May 14, 2021

**Re: Suncadia Phase 2 Division 6 - Nelson Ridge
Engineering Plan Submittal**

On behalf of New Suncadia, ESM Consulting Engineers, LLC is submitting this letter in response to your review letter we received on April 28, 2021 together with the revised construction plans. In an effort to provide concise and direct responses, we have copied the review comments below in *italics* and our responses are in **bold**.

RD-05

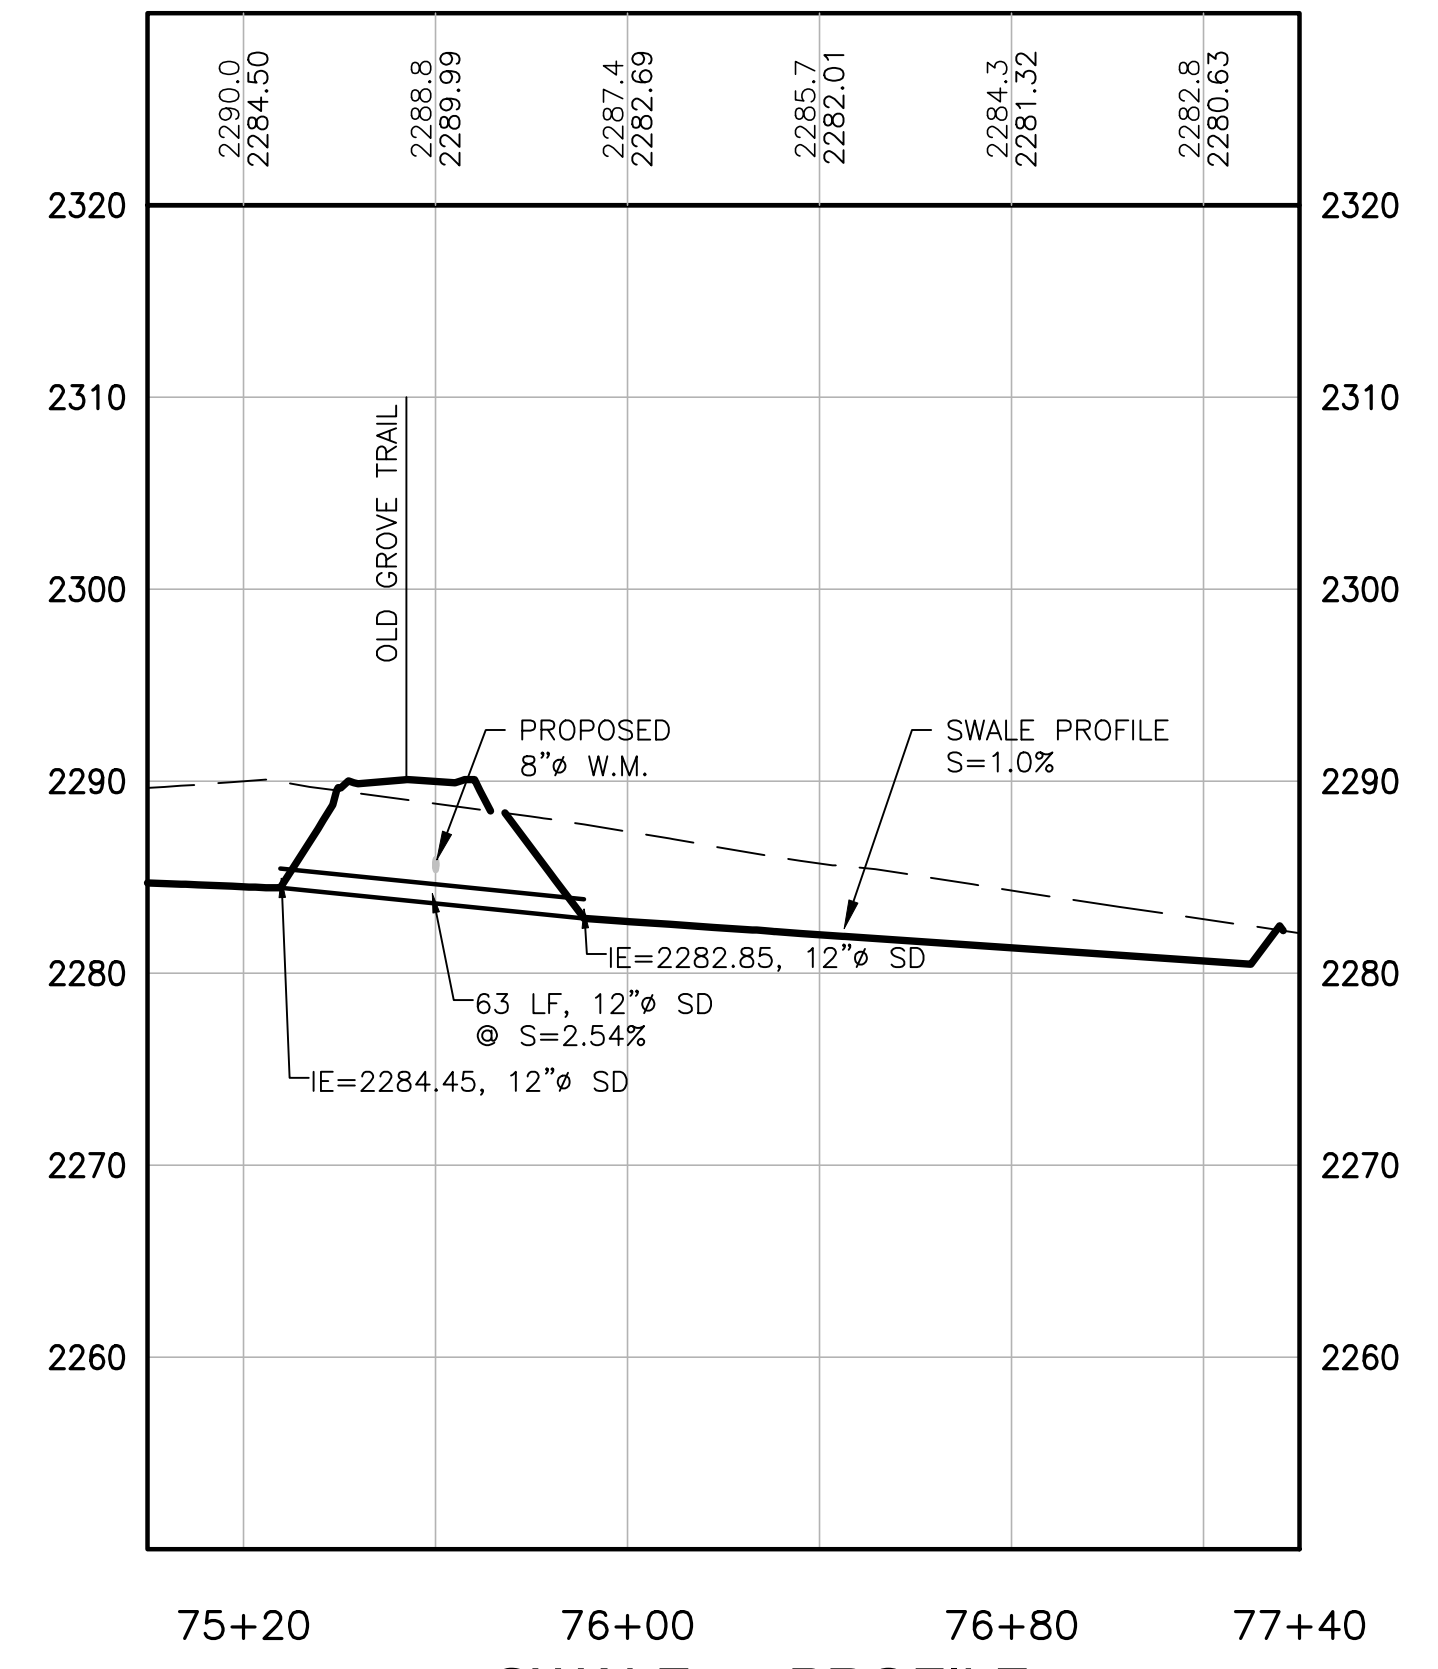
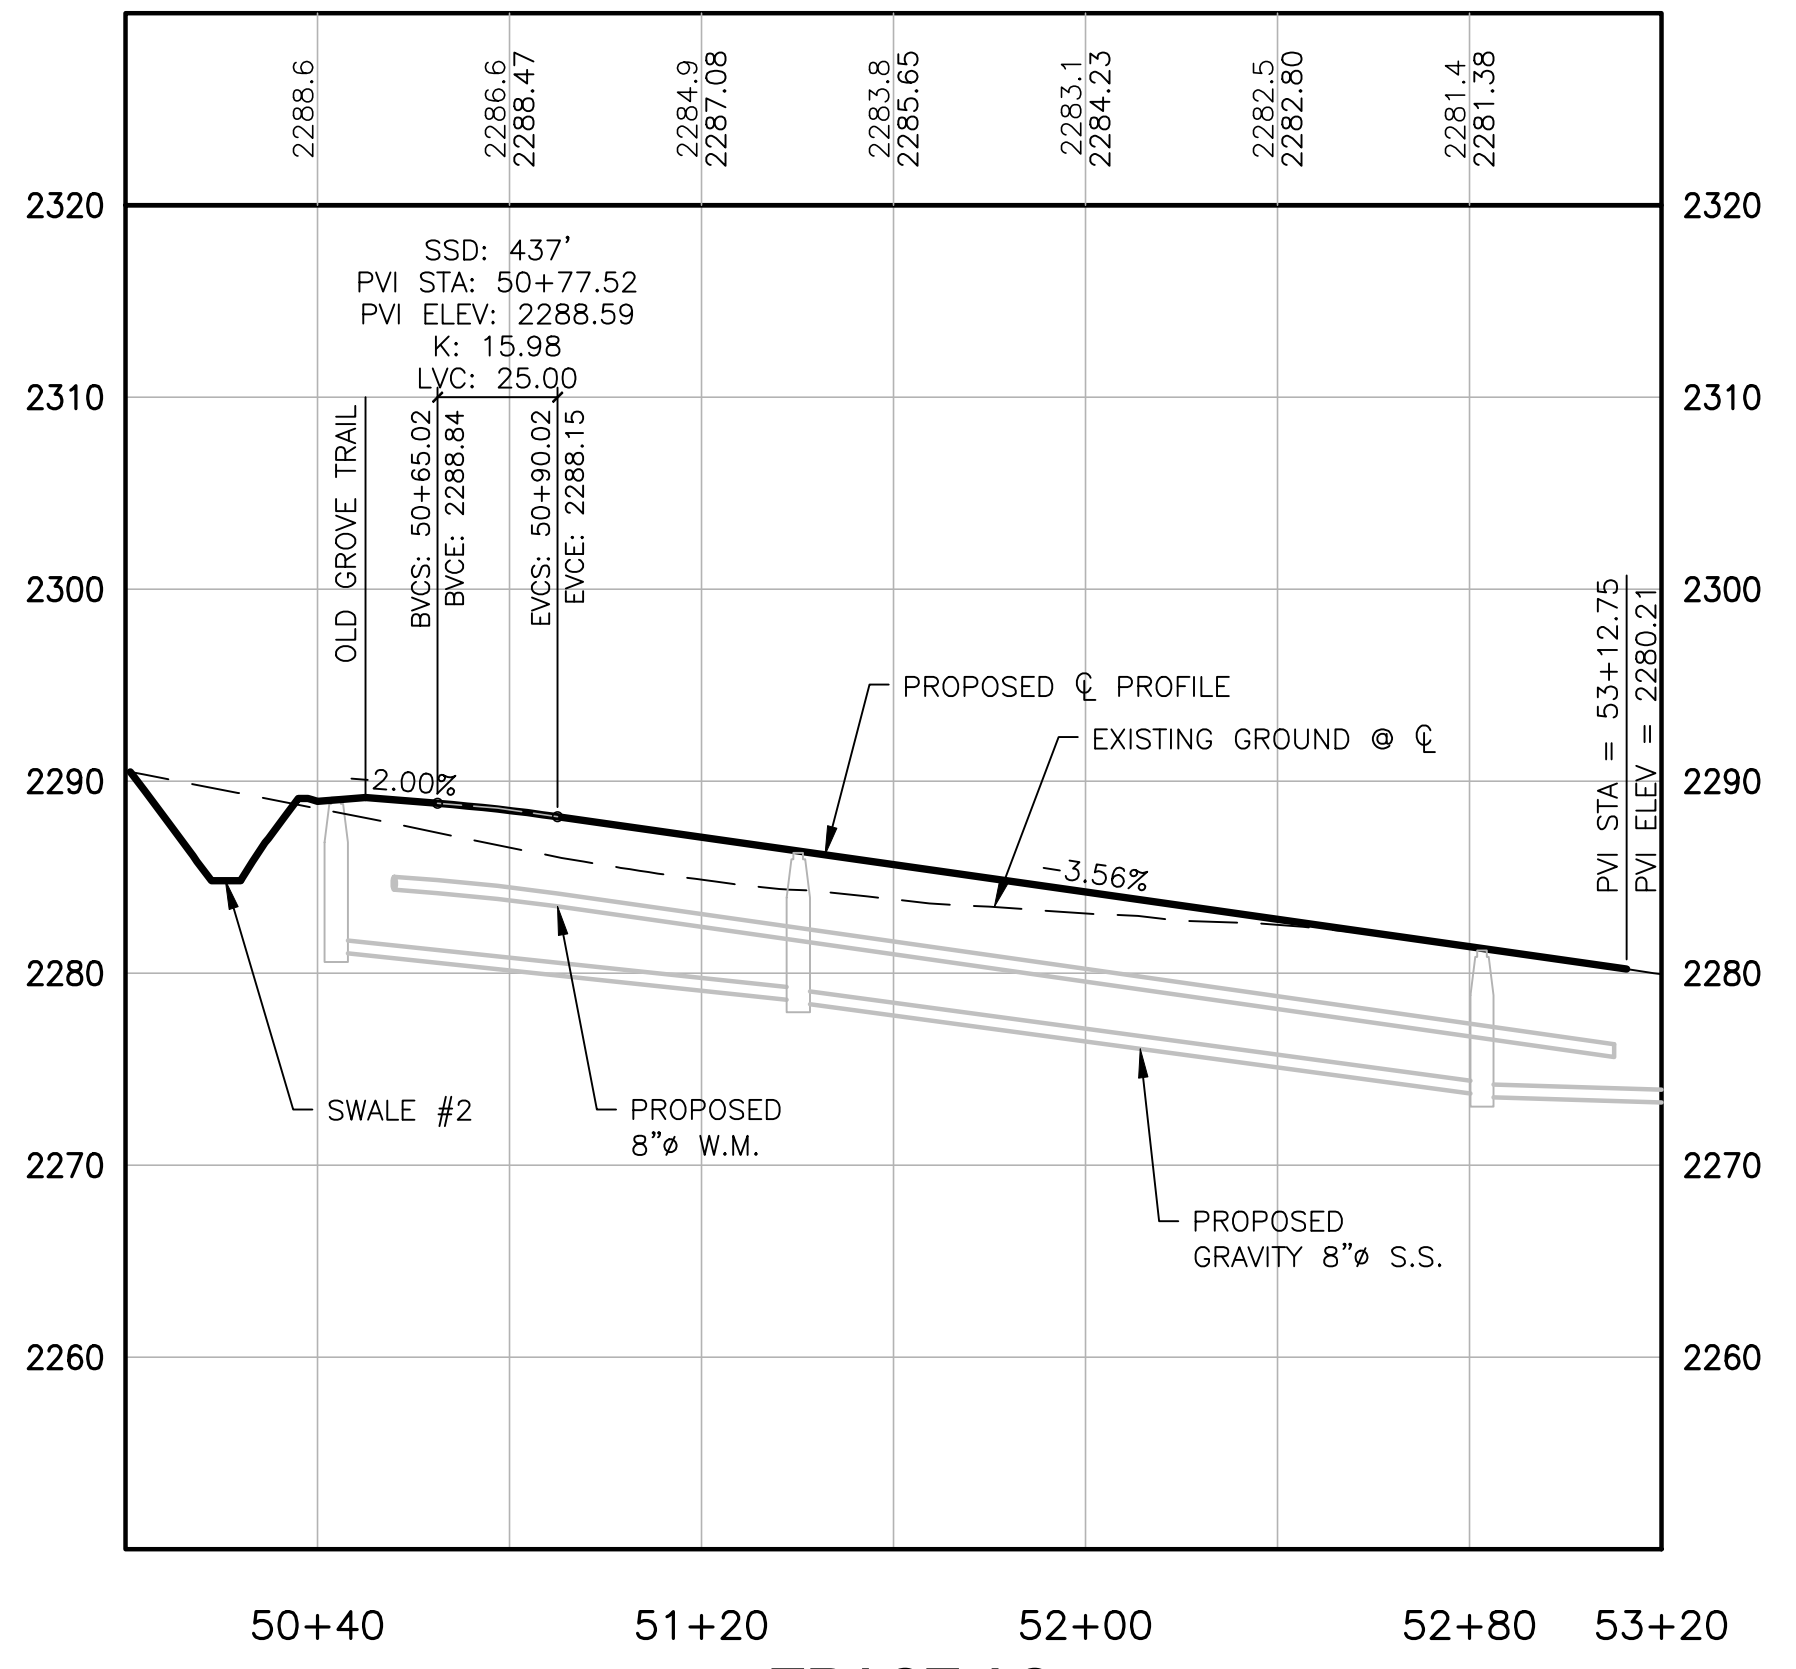
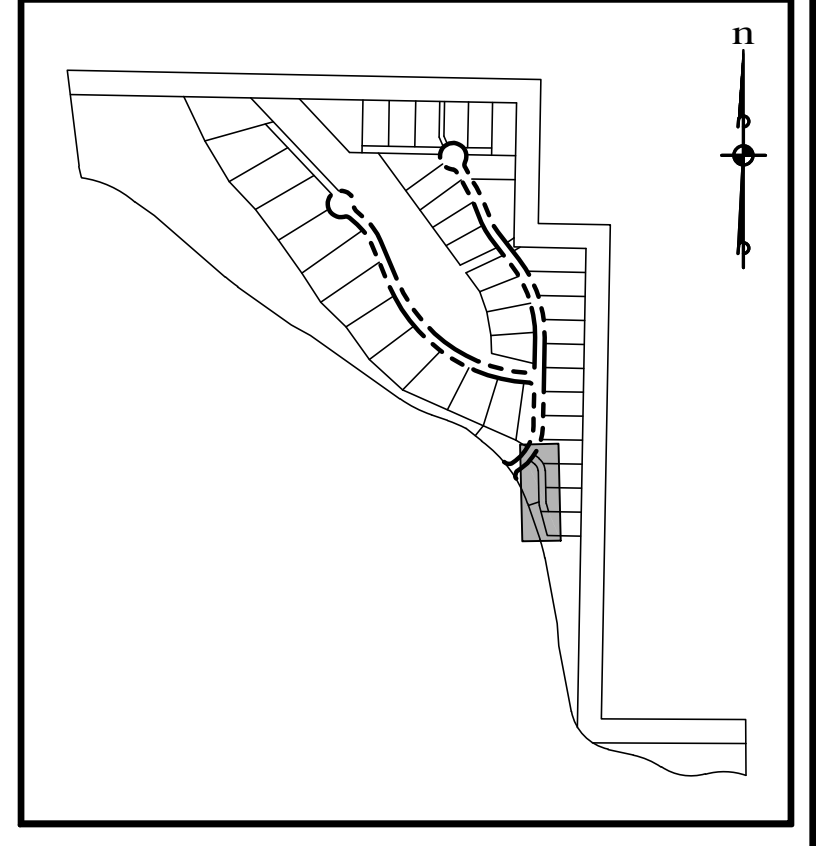
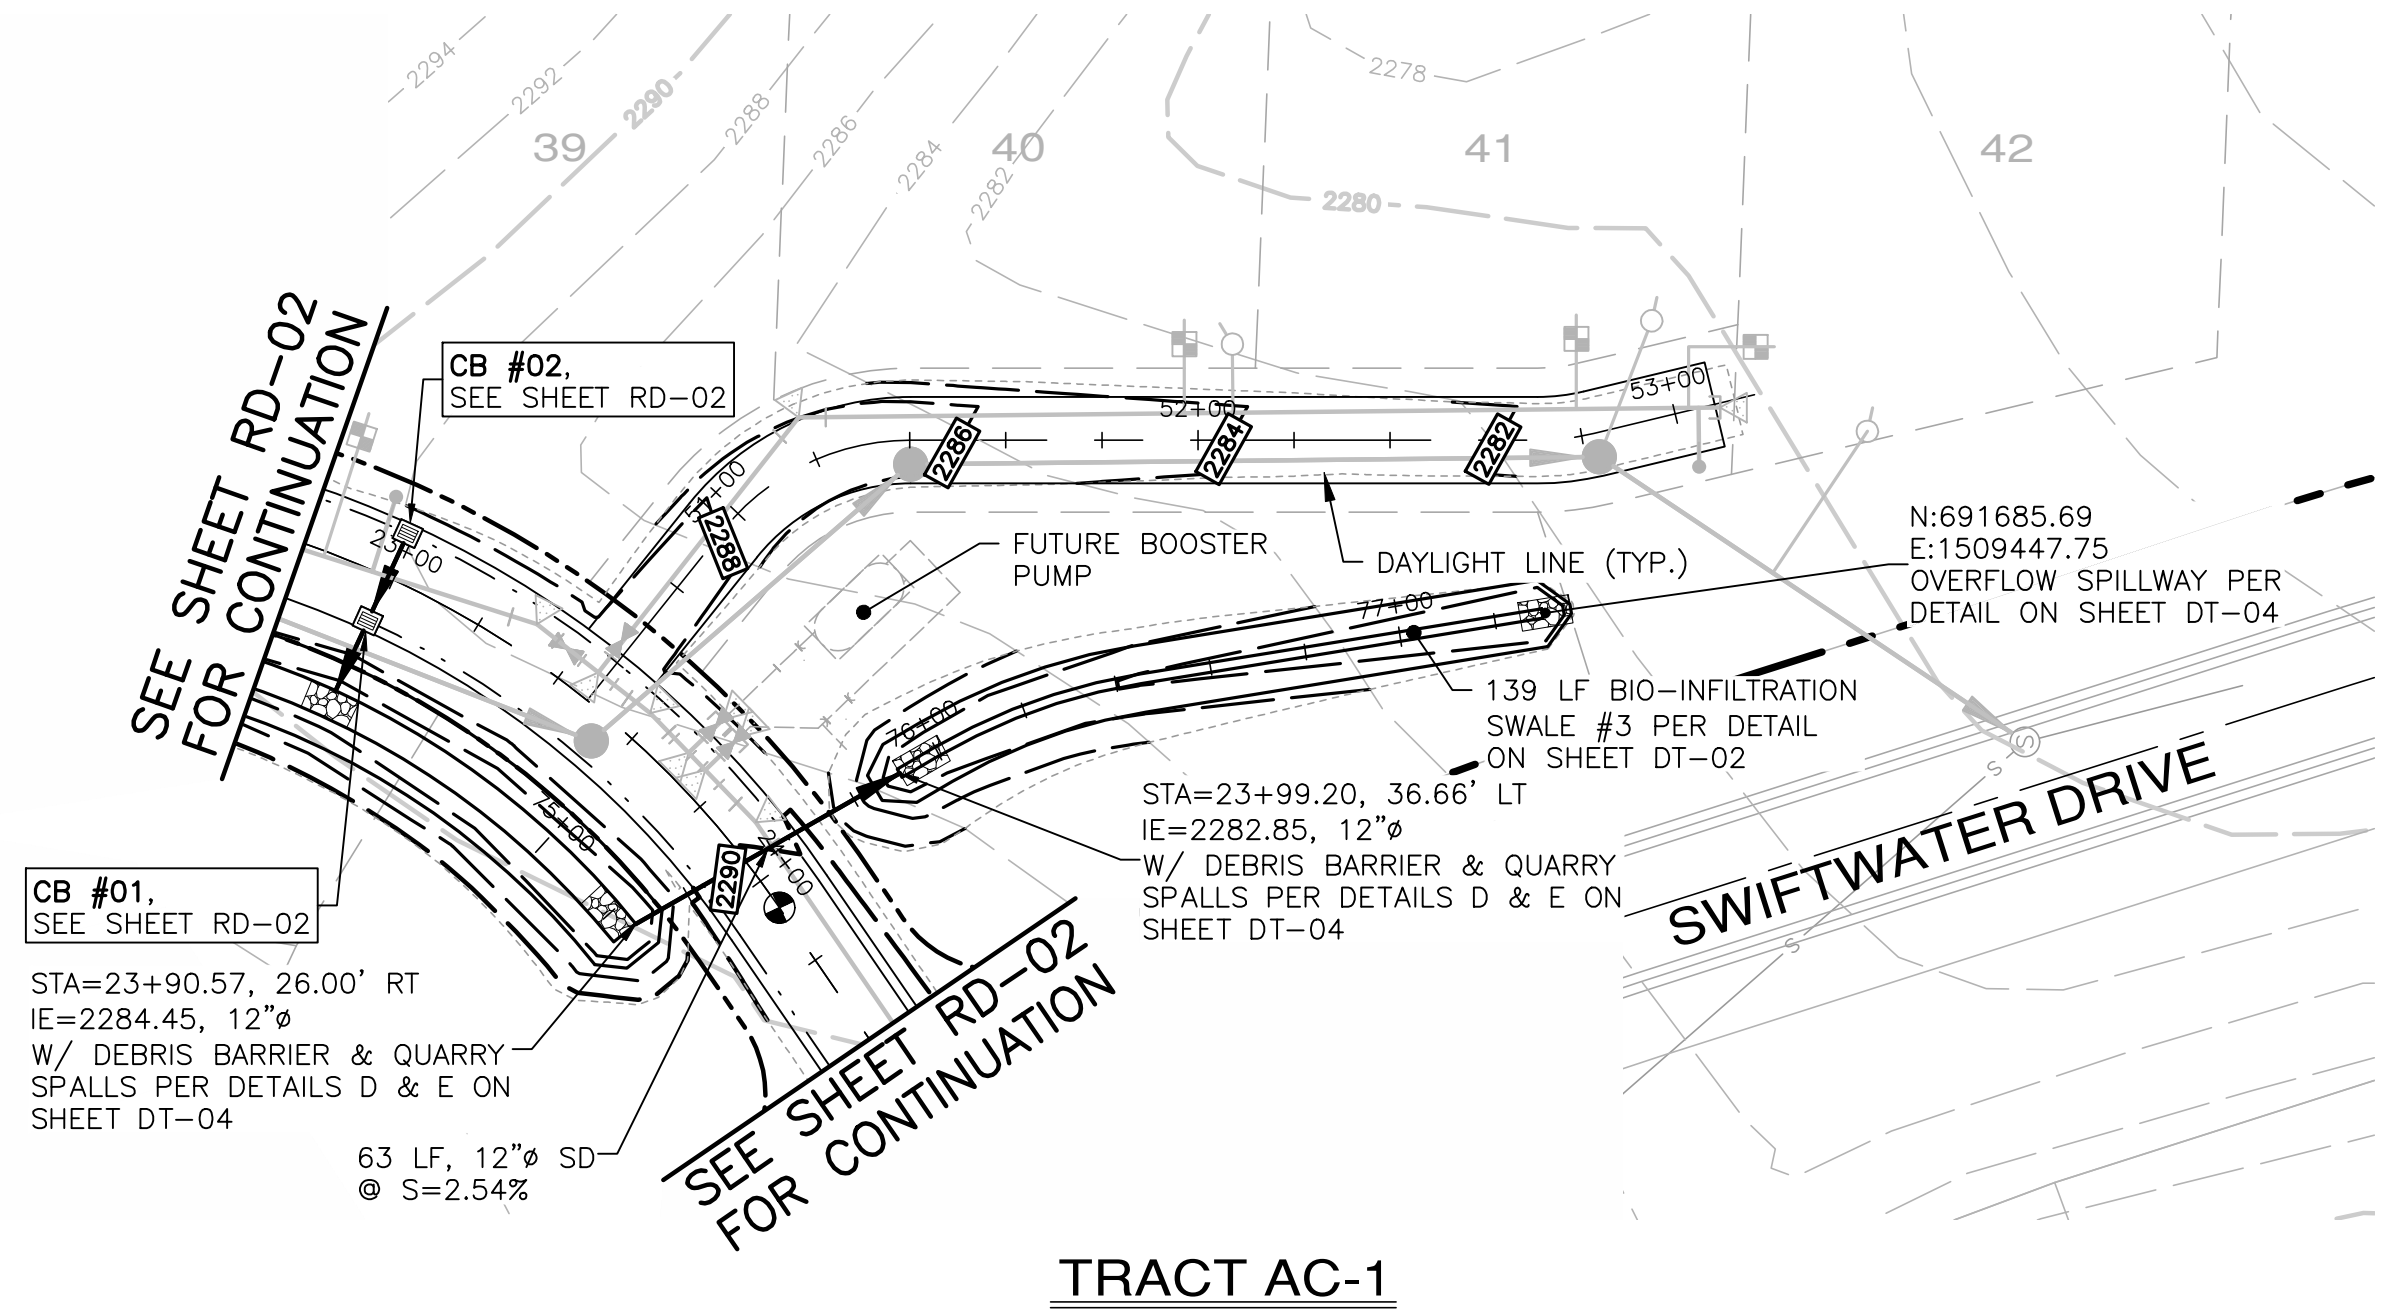
- 1. Within the plan set a number of pipes aren't labeled. Please be sure to label all pipes on sheets RD-01, RD-02, RD-05, and WS-02.*

The pipes have been labeled as requested.
